**Spring Farm Resource Recovery Facility (05_0098 MOD 5)
Section 96(1A) of the Environmental Planning and Assessment Act 1979**

I refer to the Department of Planning and Infrastructure correspondence received by the Environment Protection Authority ("EPA") on 11 November 2013 regarding an application from SITA Australia Pty Ltd (SITA) to modify the Project Approval for the Spring Farm Resource Recovery Facility, Richardson Road, Spring Farm ("the Premises"). SITA holds Environment Protection Licence No. 12588 (the "Licence") in respect of the Premises. The EPA also refers to its correspondence dated 4 October 2012 providing comments on the first draft of the proposal.

The EPA has reviewed the Environment Assessment dated 30 October 2013 prepared by Cardno NSW/ACT and provides the following advice/comments:

Figure 8-4 Predicted 99th percentile ground level odour concentration due to ARRT/MRF operations only

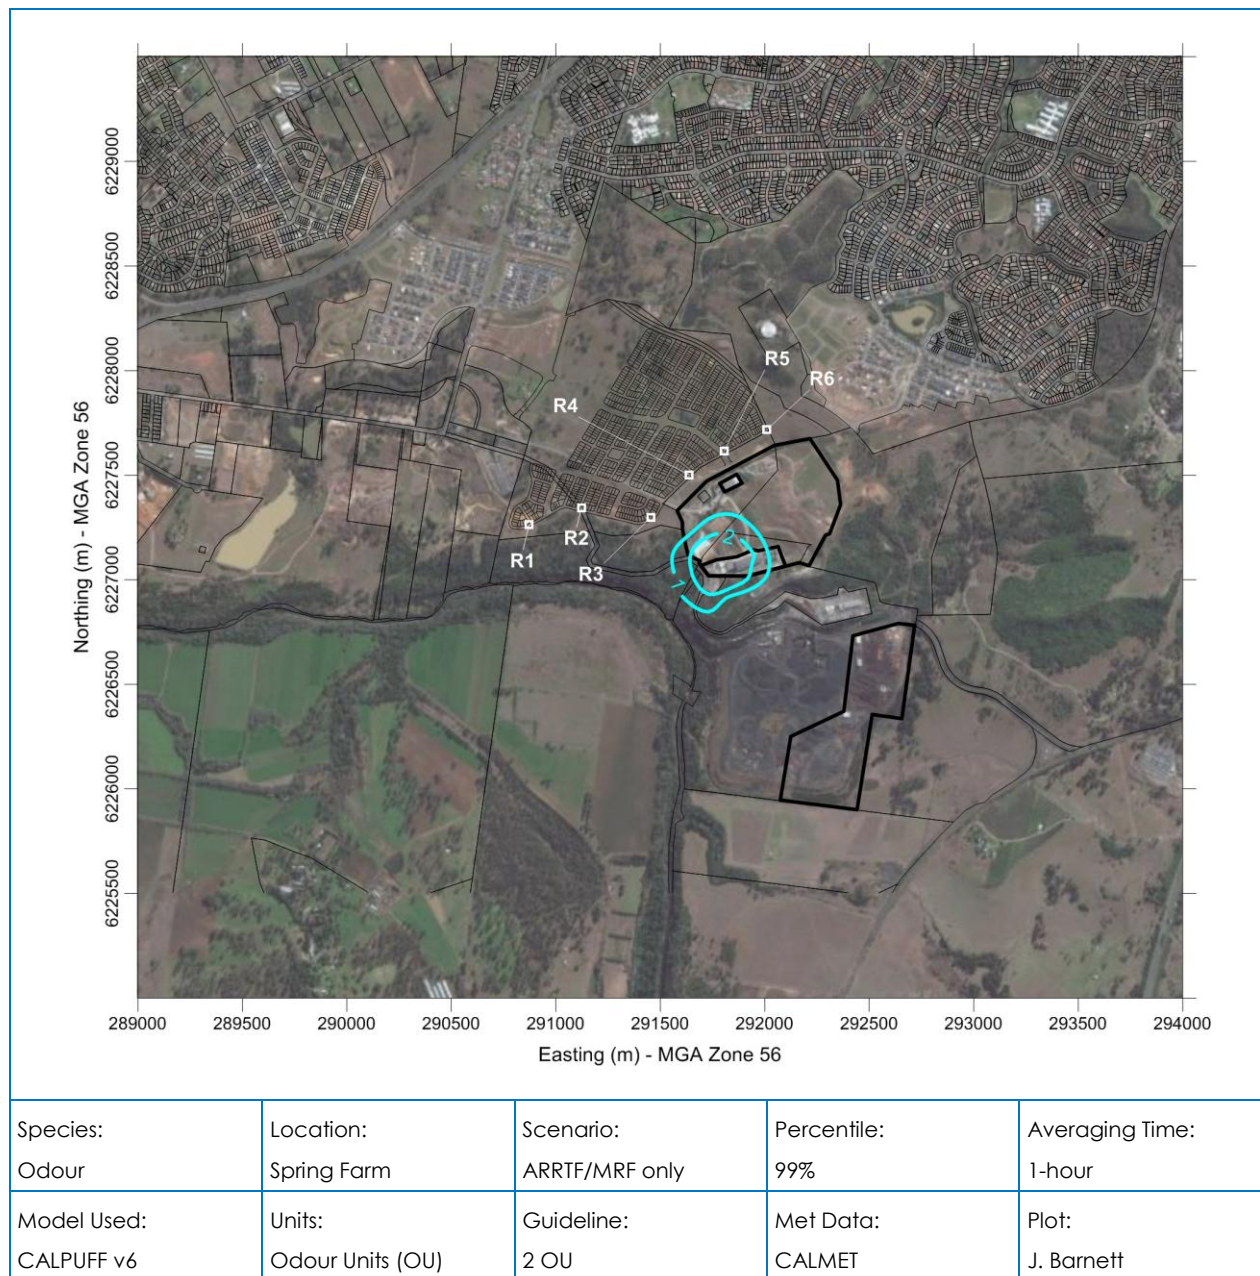
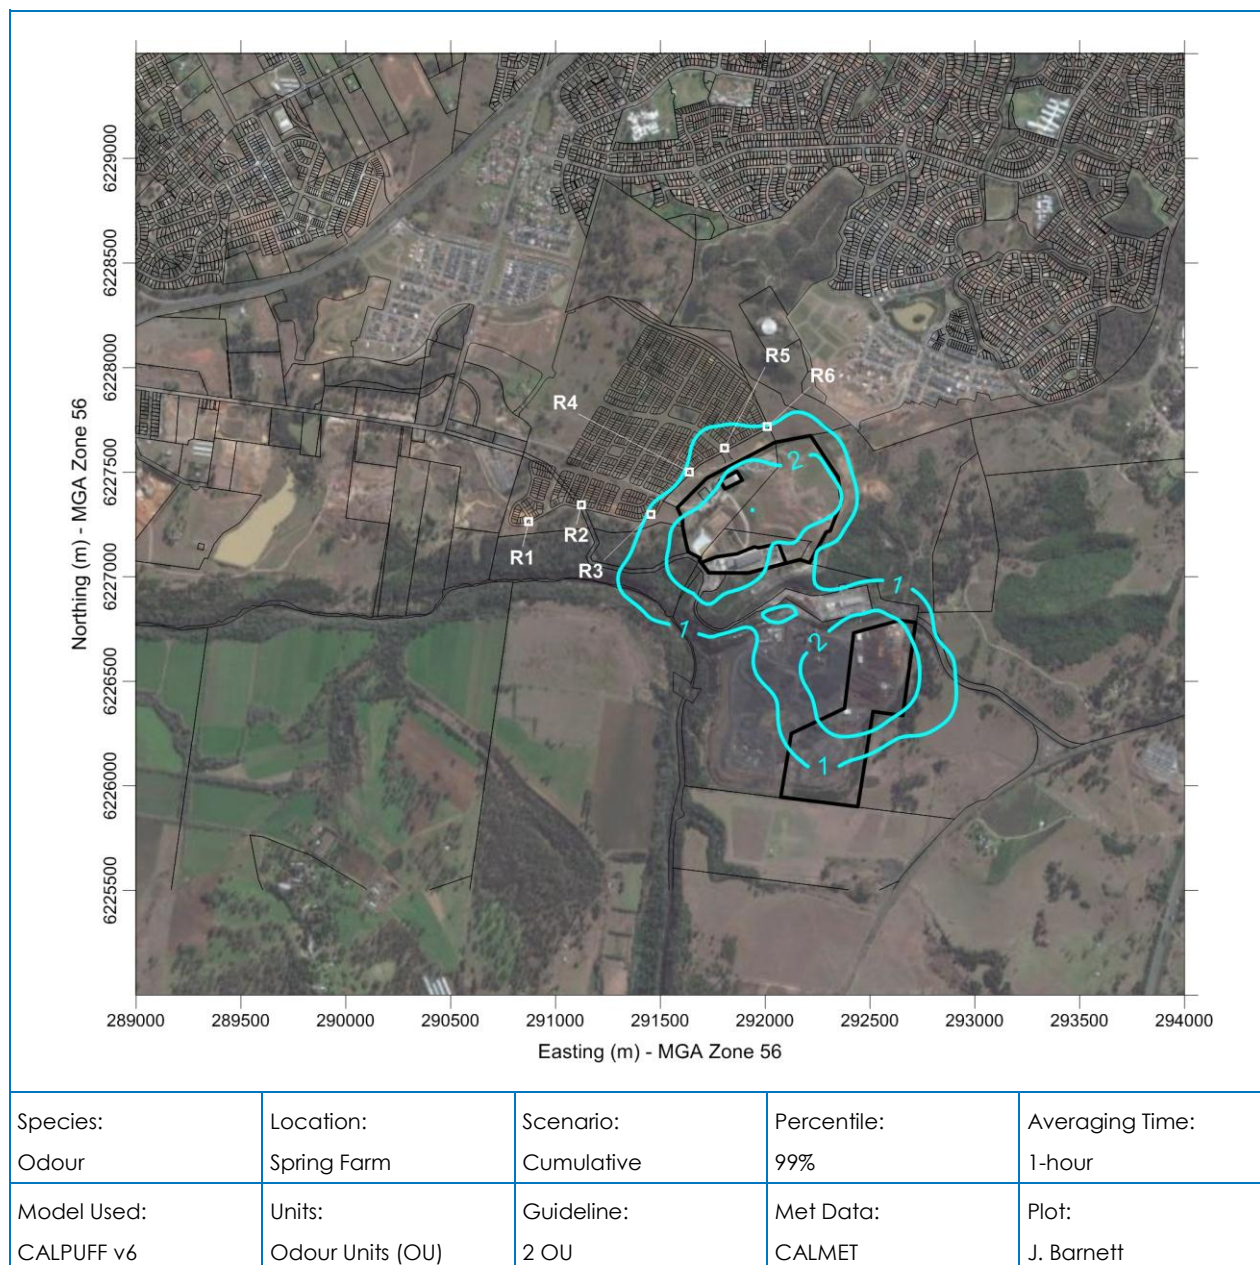
7. Management of tank de-sludging has not been included in the Environment Assessment.
8. EPA review of the odour modelling indicates that the assessment is inadequate and EPA recommends the assessment should be revised to demonstrate impacts have been robustly and realistically assessed (see attachment A)

1) Modelling results show compliance with the adopted Project odour criterion however there appears to be a discrepancy between model results and actual odour impacts

Despite the history of ongoing odour complaints in the area surrounding the Project site, the Project dispersion model predicts compliance with the Project odour criteria of 2 OU and consequently minimal risk of adverse odour impacts at existing or proposed future residential receptors.

Consequently the dispersion model results do not appear to be representative of existing odour impacts at residential receptors in the vicinity of the Project. This indicates the modelling assessment does not adequately estimate the risk of adverse odour impacts.
